Application for a non-material amendment following a grant of planning permission.

- 1 - Slight reduction in height of the roof above the garage required for structural reasons.
- 2 - Change of front window (no neighbour impact) of second storey extension due to removal of en-suite.

DRG No AB/E+EDC/09 B

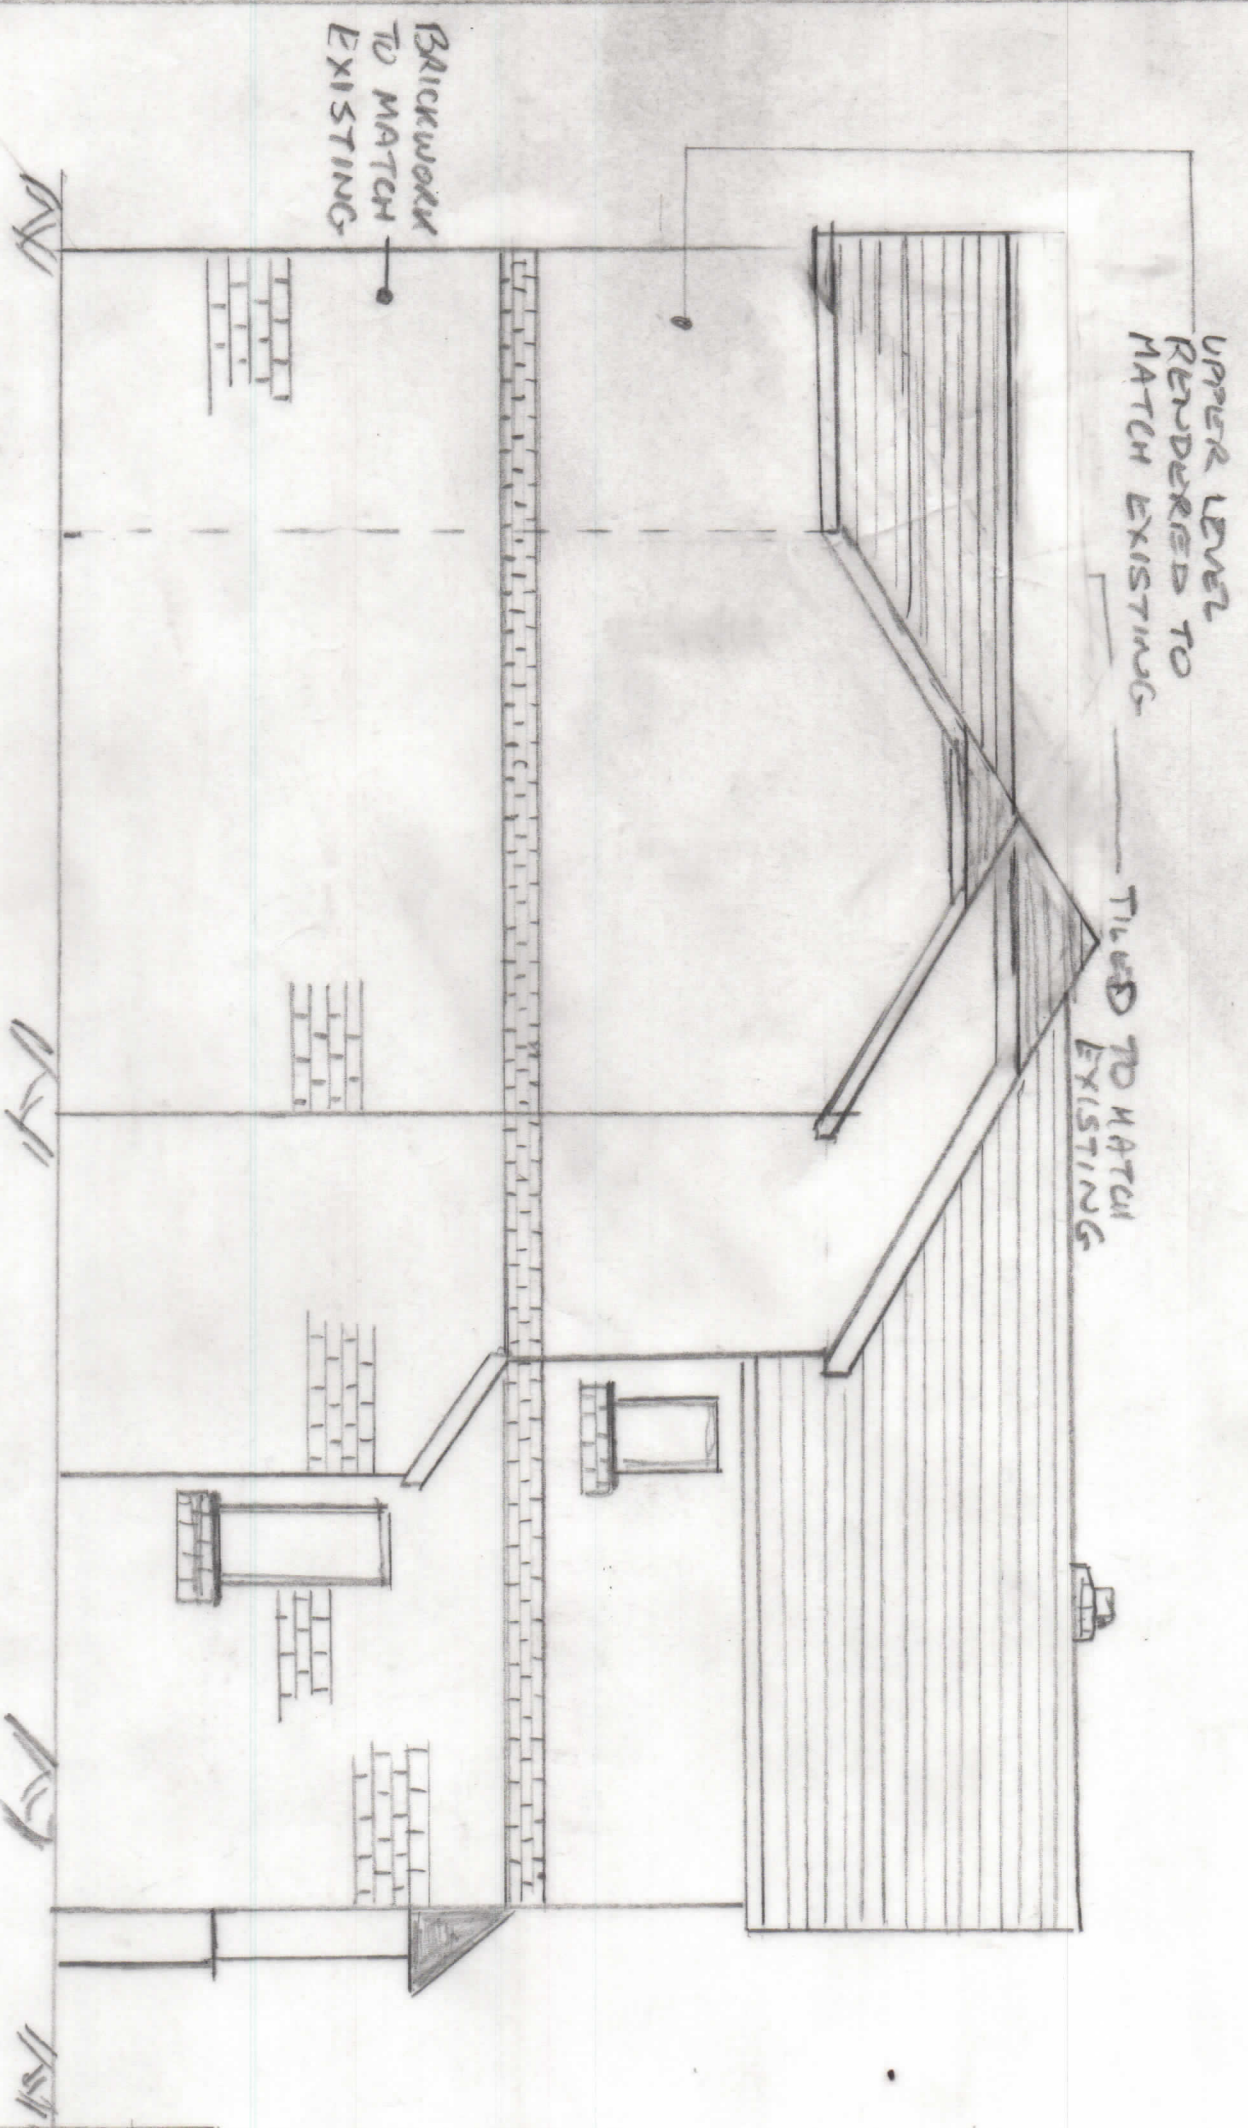
AB/E+EDC/09 Revision B
AB/E+EDC/10 Revision A
AB/E+EDC/13 Revision B
AB/E+EDC/15 Revision A
Image of new roof structure and windows

- 1 (Slight reduction in roof height) - During the build it was determined by the structural engineer & builder that the original plans for the roof would not actually be possible with the loads on the steel beams. Therefore the height of the roof above the garage has been reduced to fall in line with the existing roof structure.
- 2 - As en-suite has been removed from the plan due to cost, the window has been changed from a small frosted bathroom window, and has been replaced with a larger bedroom window.
This window has been made larger to comply with fire regulations to provide an escape route in case of a fire.
